Comments on the applicant's Response to the Examining Authority's First Written Questions (EN070008/EXAM/9.9) on behalf of the residents of Corner Farm (These are submitted at this deadline to simplify unavoidable cross-references with comments on the applicant's Comments on Written Representations below.)
Interested Party reference number: 2004715
Deadline 3

Comments on the Applicant’s Comments on Written Representations (EN070008/EXAM/9.18) on behalf of the residents of Corner Farm

Interested Party reference number: 2004715

Fig. 1 Alternative E-1B/E-2 Route (with link in pink)

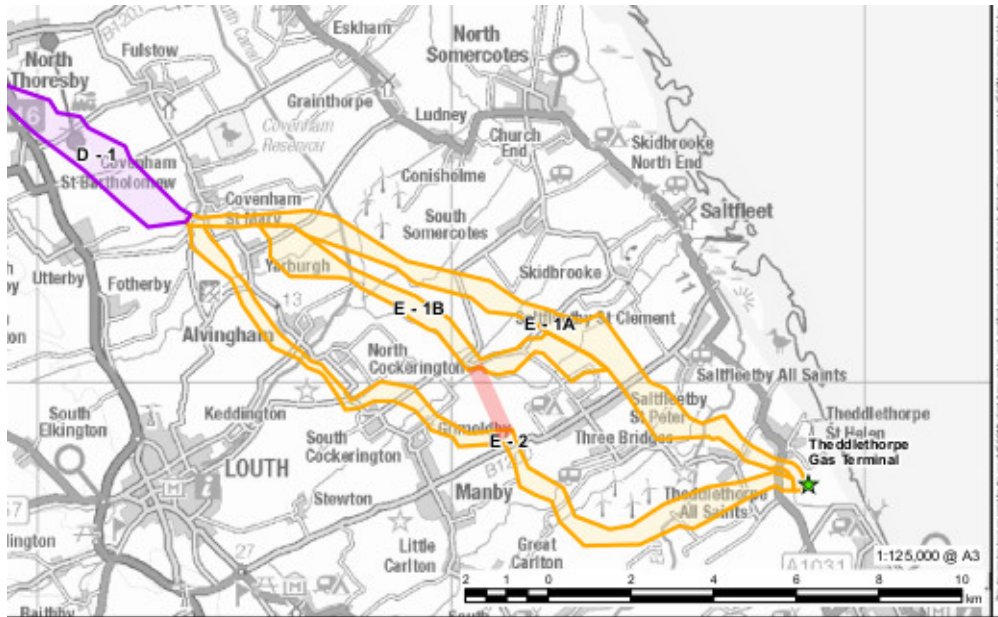
2.20.19 – The applicant fails to say why it would not consider reversing the “minor diversion to the east” on route E-2 in the interests of safety. It has shown only mitigation of risk and not of consequences. Safe distance is intended to mitigate consequences. The applicant’s determination not to address the consequences of pipeline rupture shows a somewhat cavalier attitude to public safety.

As previously pointed out to the applicant, the marginal incursion into flood zones 2 and 3 along route E-1B is small compared to the great swathe of flood zone encountered after their preferred route crosses the B1200. This argument is specious. If the applicant was so concerned about flood-zone incursion, it would not have countenanced the “minor diversion to the east”. The “risk to people working within the flood plain” is routinely controlled and will need to be after the route crosses the B1200. This is not a substantive objection.
